Project Name: *Cherry Hills Unit 1*

RE: Request for Final Sign-Off for Southwest Federal Credit Union

On behalf of the applicants, we request a final DRB sign-off for the property legally described as. On June 10, 2010, the Environmental Planning Commission conditionally approved a Site Development Plan for Building Permit. This document outlines how each EPC condition has been met. Conditions are in normal text; *applicant responses are italicized.*

On June 10, 2010 the Environmental Planning Commission voted to approve Project 1008147/10EPC-40026, a Site Development Plan for Building Permit, for Tract C1A4A Cherry Hills Unit 1, based on 13 Findings and subject to the following Conditions:

SOUTHWEST FEDERAL CREDIT UNION
SITE PLAN FOR BUILDING PERMIT

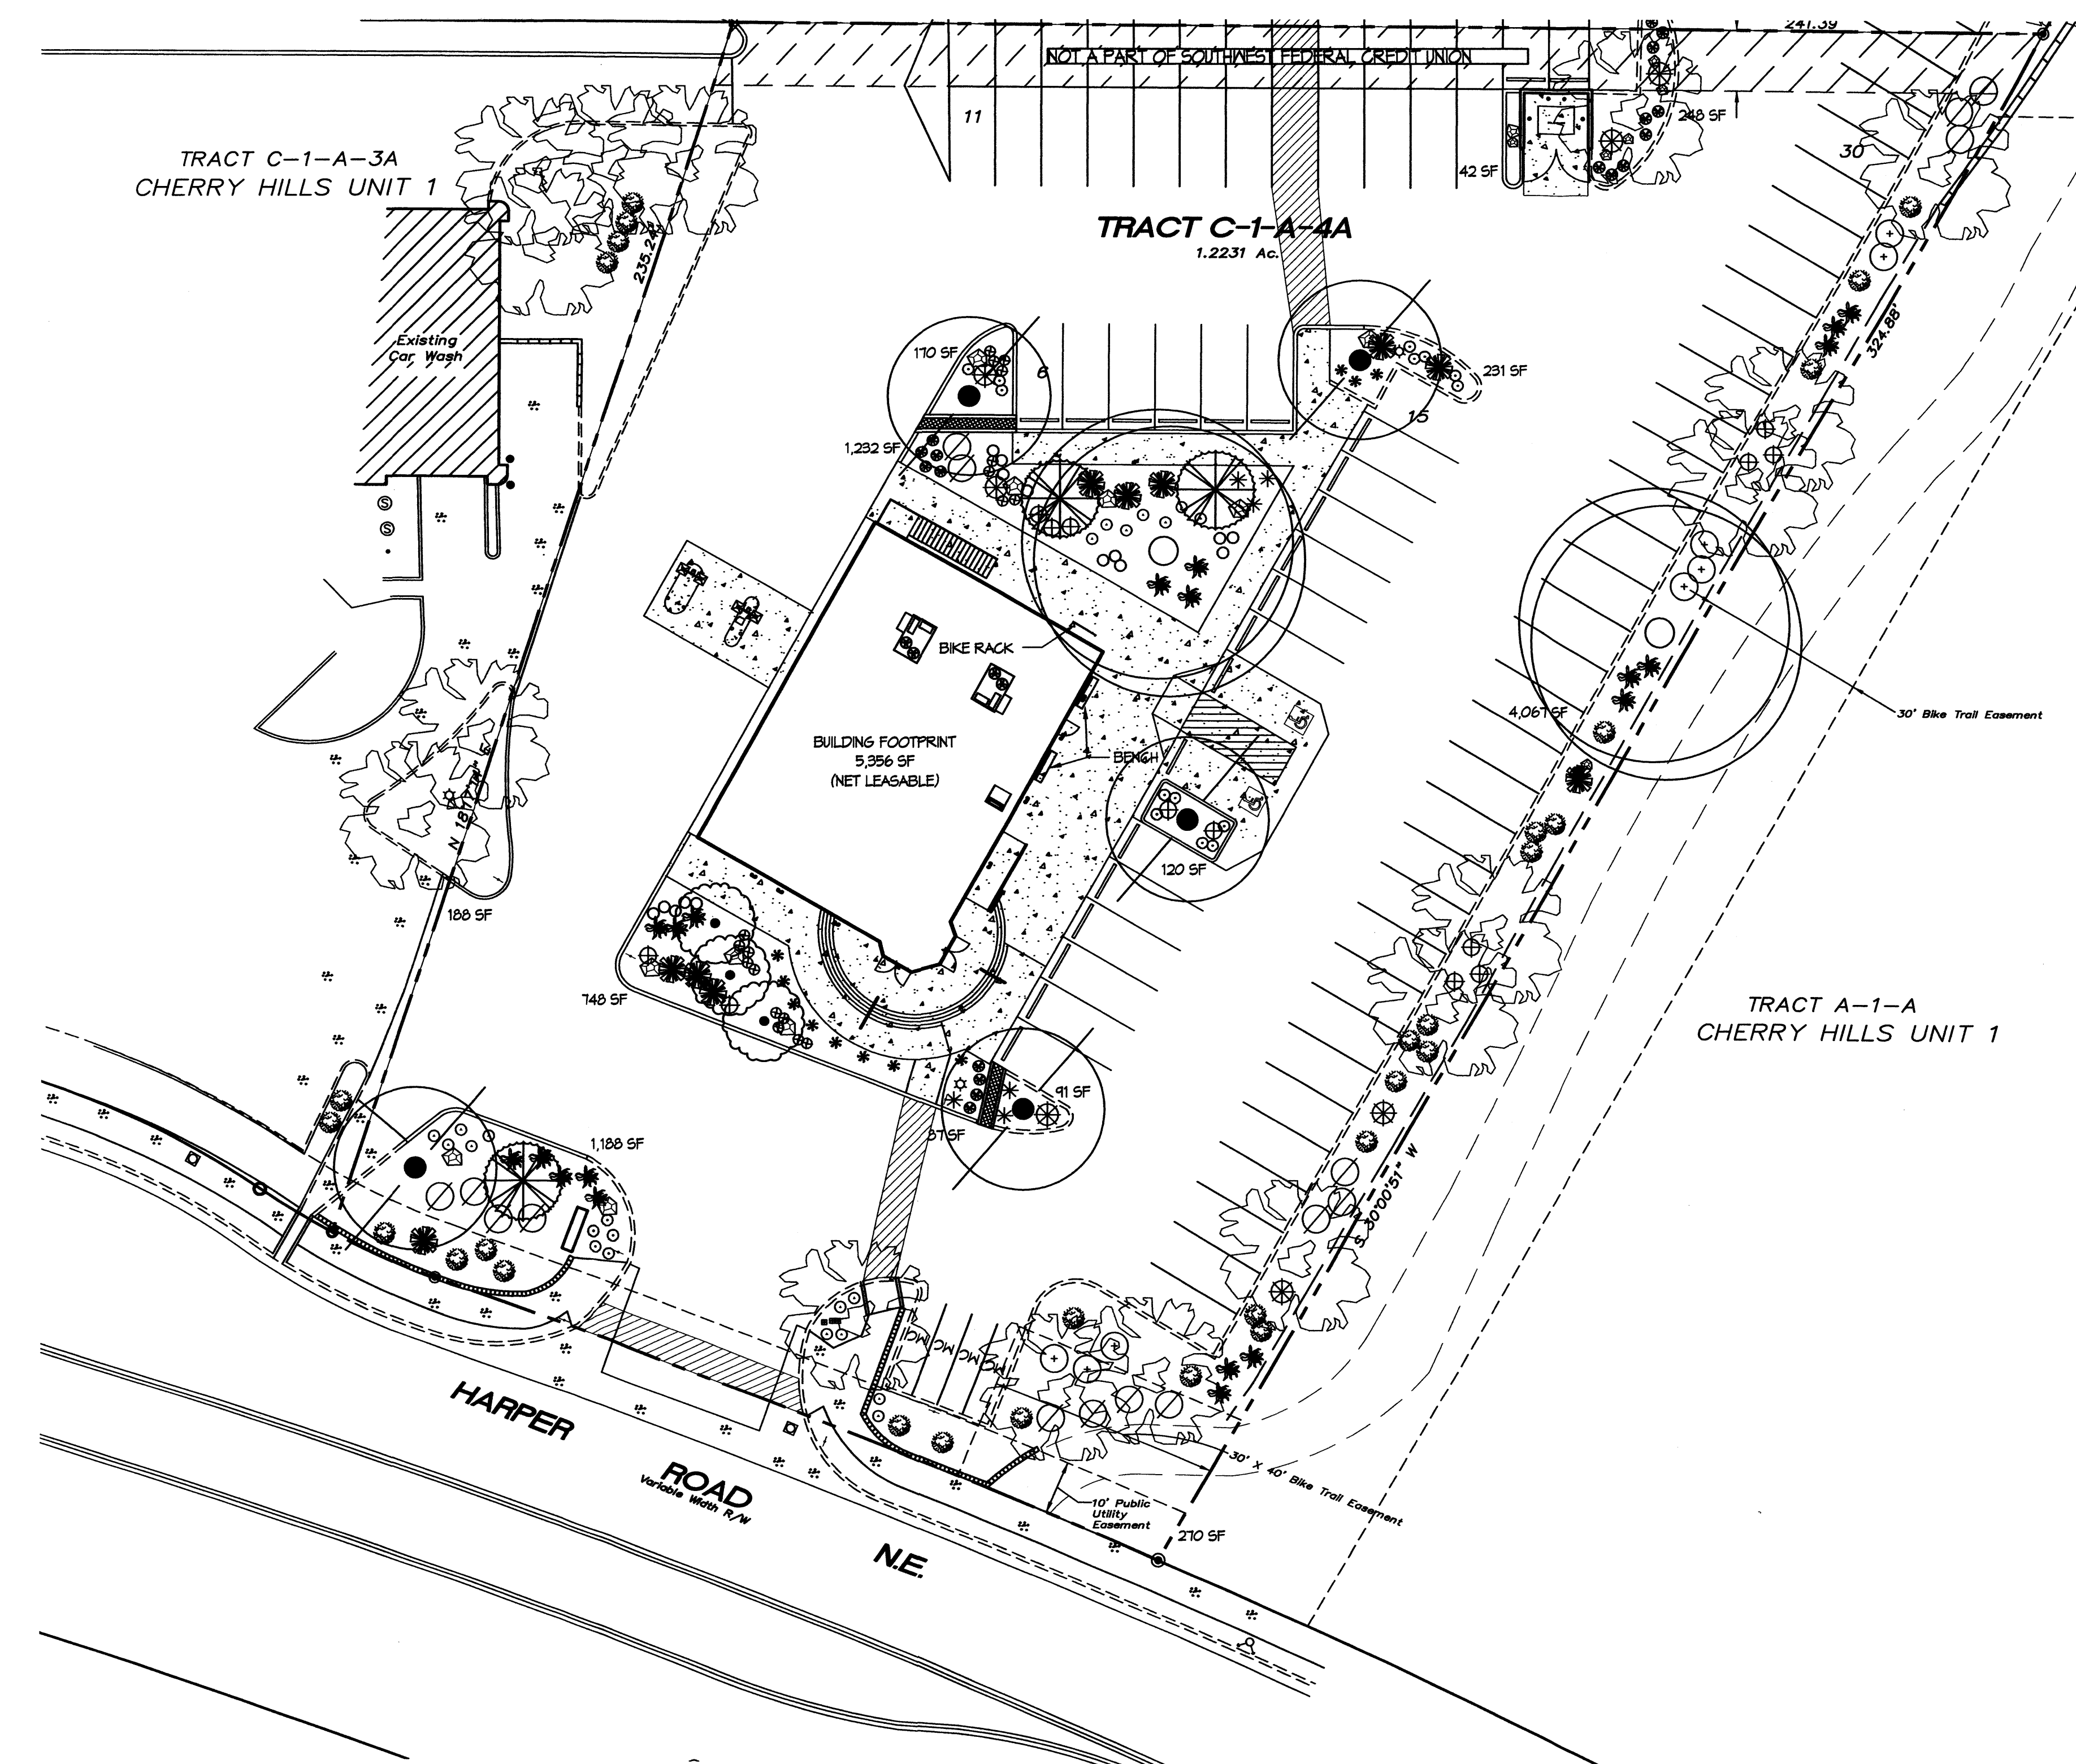
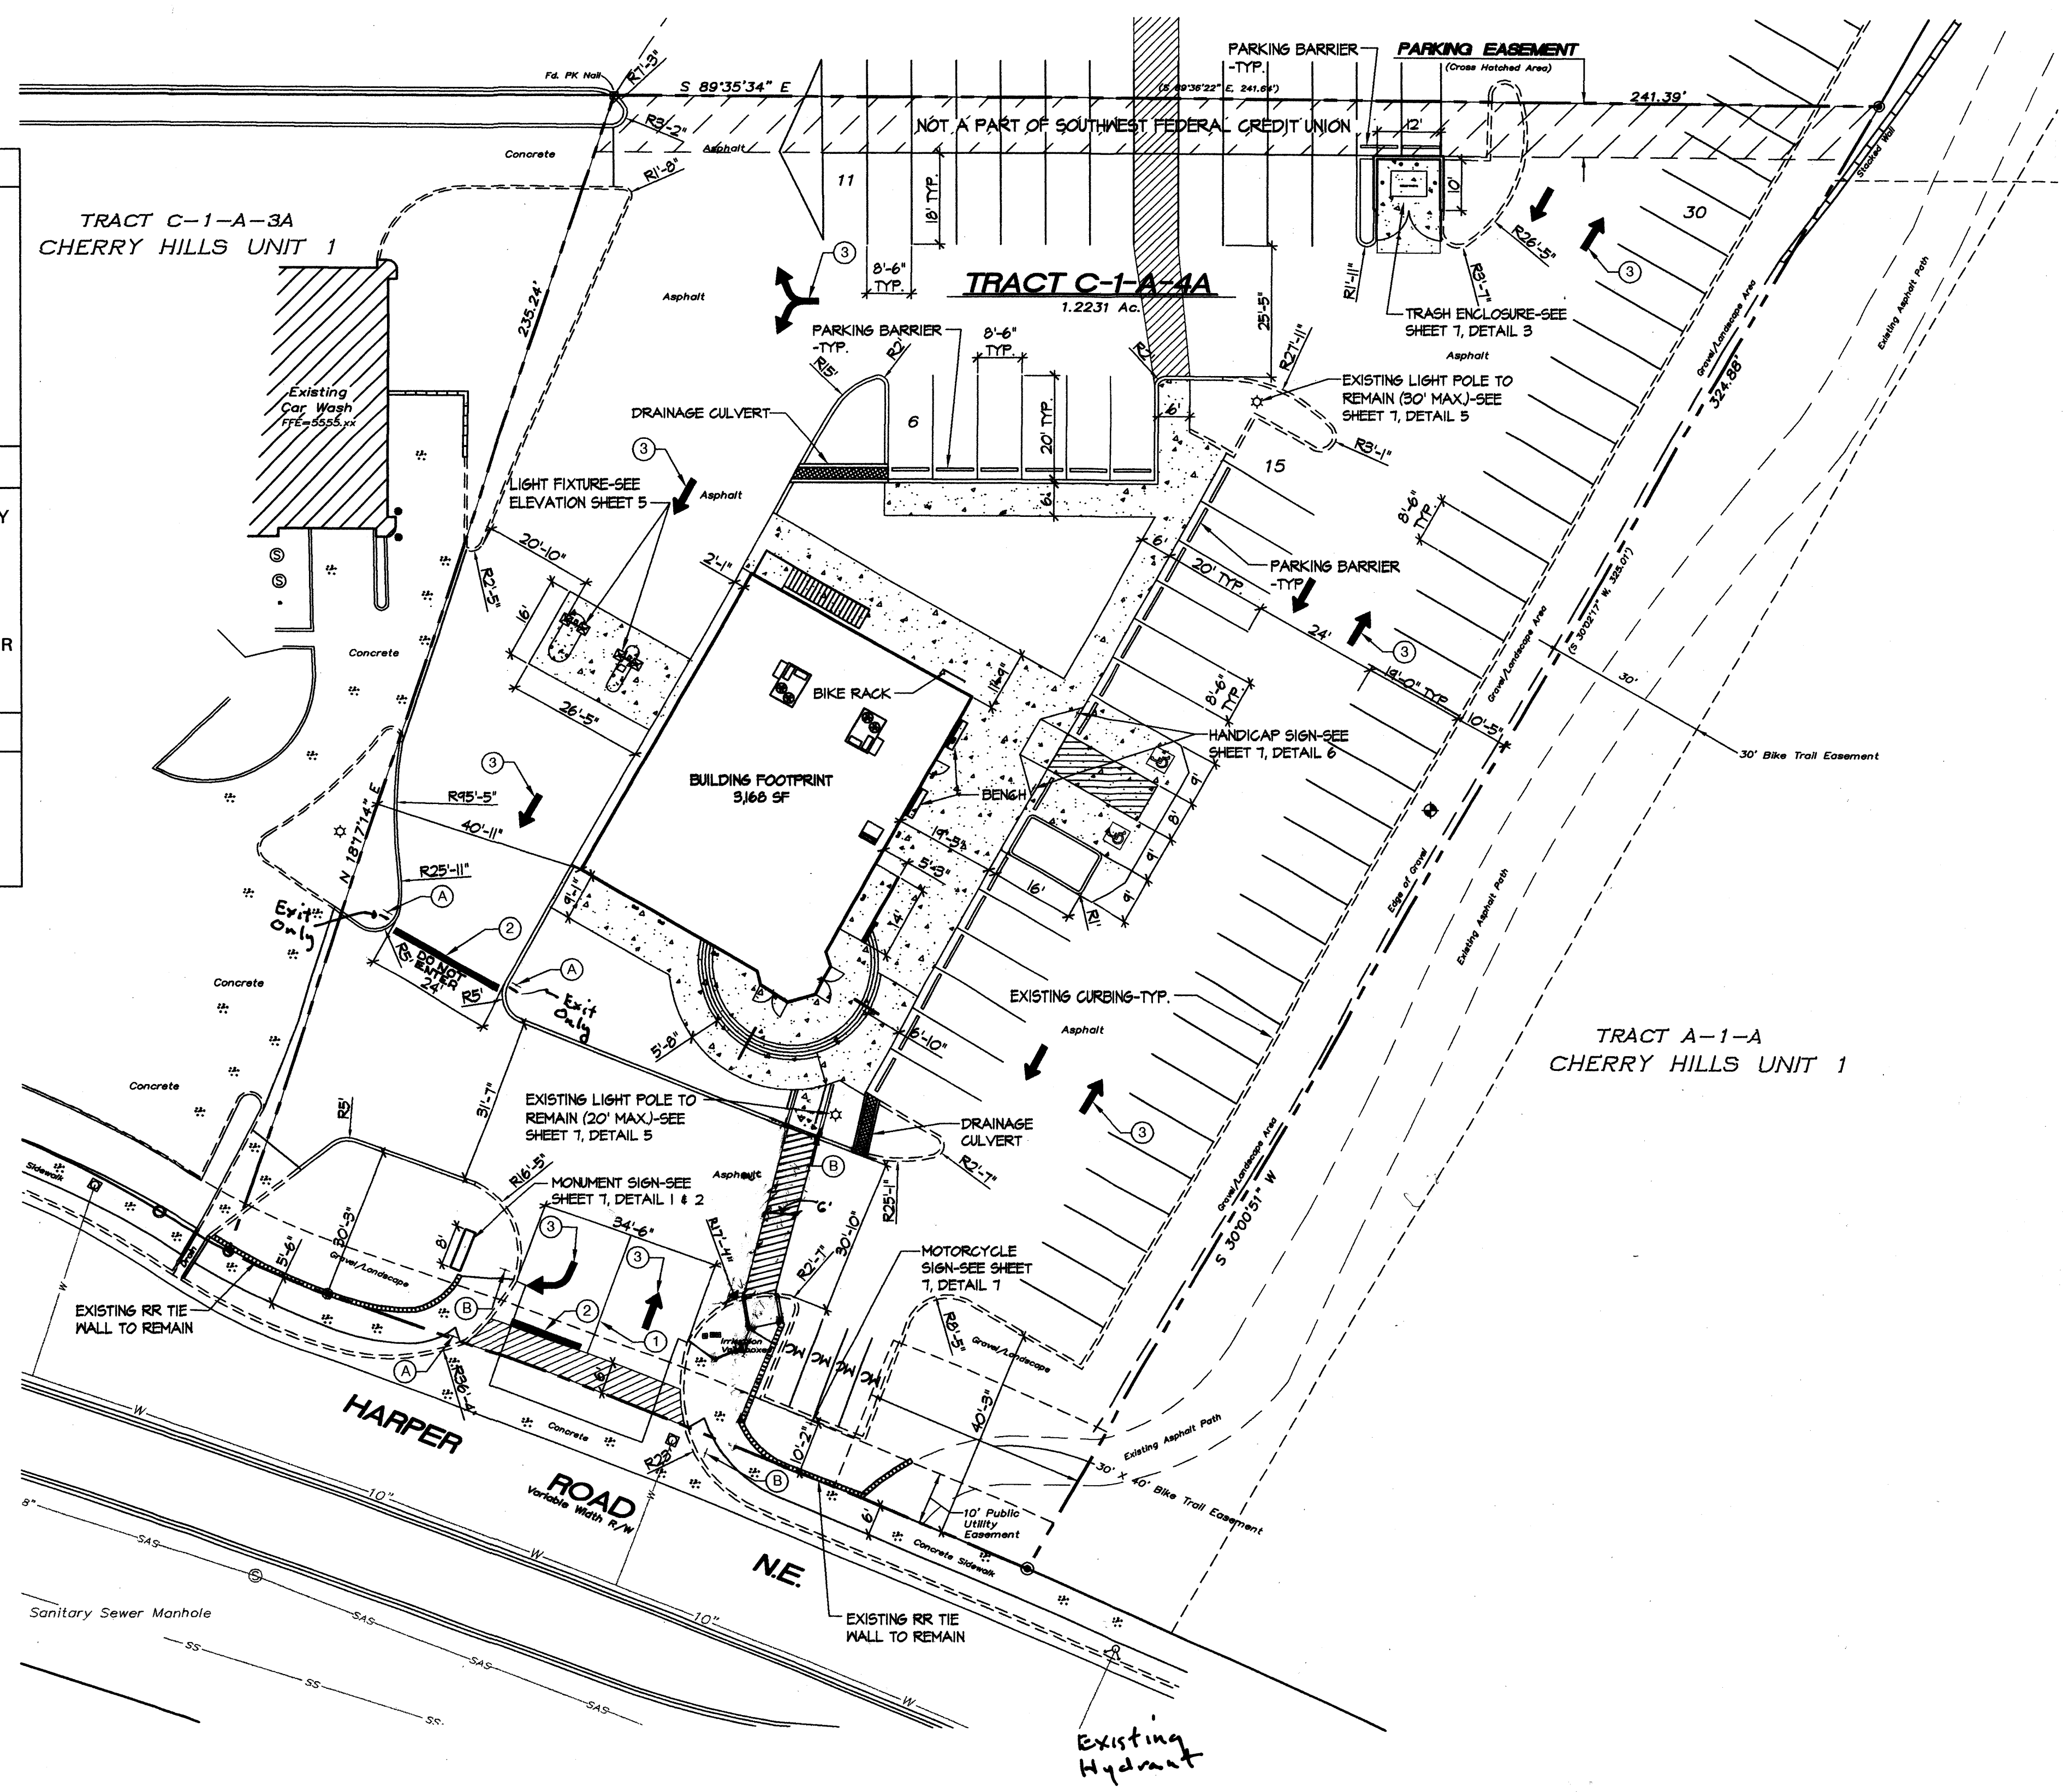
3. The applicant shall demonstrate, through the addition of a note or Notes on the site development plan, how the Energy Management Goal, Section II.D.3 of the Comprehensive Plan is furthered.

- a. Correct the language for the existing zoning to provide the complete and accurate zoning of the site.
The existing zoning language was amended to provide the complete zoning description.
- b. Add the maximum building height of 26 ft. and the minimum setback of 20 ft.
Sheet 1 was amended to include these restrictions.

5. Add a general note stating that the site development plan shall comply with the approved site development plan for subdivision for tracts C1A1A through C1A5A (Z-93-95).

- b. Narrow drive-up exit, at east/west drive aisle, to 24'. Replace wrong way signs with exit only signs (new letter B in legend). Add left and right turn arrow pavement markings (optional).
Agreed, the exit was narrowed to 24'. Need clarification from the DRB concerning signage requirements.

- c. For the left turn arrow pavement marking, designated with keyed note #4, remove the word "only" and add a directional arrow pavement marking.
Agreed, the site plan was modified to reflect this condition.

- d. Delete the work "only" attached to all directional arrow pavement markings.
Agreed the site plan was modified to reflect this condition.
 - e. In legend, delete signs B, D, E and F.
Agreed, the legend was modified.

- f. For the purpose of minimizing conflicts between vehicles parking, vehicles exiting the credit union drive-up area and vehicles entering or exiting the fueling facility to the west, the applicant should eliminate the existing 3 parking spaces fronting Harper adjacent to the existing drainage feature.
Agreed, the three parking spaces have been eliminated.

9. A pedestrian crosswalk of the same width as the sidewalk shall be added across the site drive on Harper Road.
Agreed, the additional crosswalk has been added.

- a. General Note 1 shall be deleted since it is no longer relevant.
General Note 1 was eliminated.
 - b. The "20 ft" label shall be corrected on the site plan and landscape plan to begin at the property line rather than the front of curb.
The dimension labeling for the landscaping along Harper has been modified for all areas.

Sheet 1 of the Site Plan was amended to include General Note #7 that addresses this condition.

Sheet 1 of the Site Plan was amended to include General Note #8 that addresses this condition.

Sheet 1 of the Site Plan was amended to include General Note #11 that addresses this condition. The grading plan was also prepared with water harvesting in mind.

A meeting was held with Solid Waste staff and an option was to provide a note that describes that recycling bins shall be inside the building and that the Credit Union will maintain a contract with a private company for recycling of paper products. General Note #12 has been added to Sheet 1.
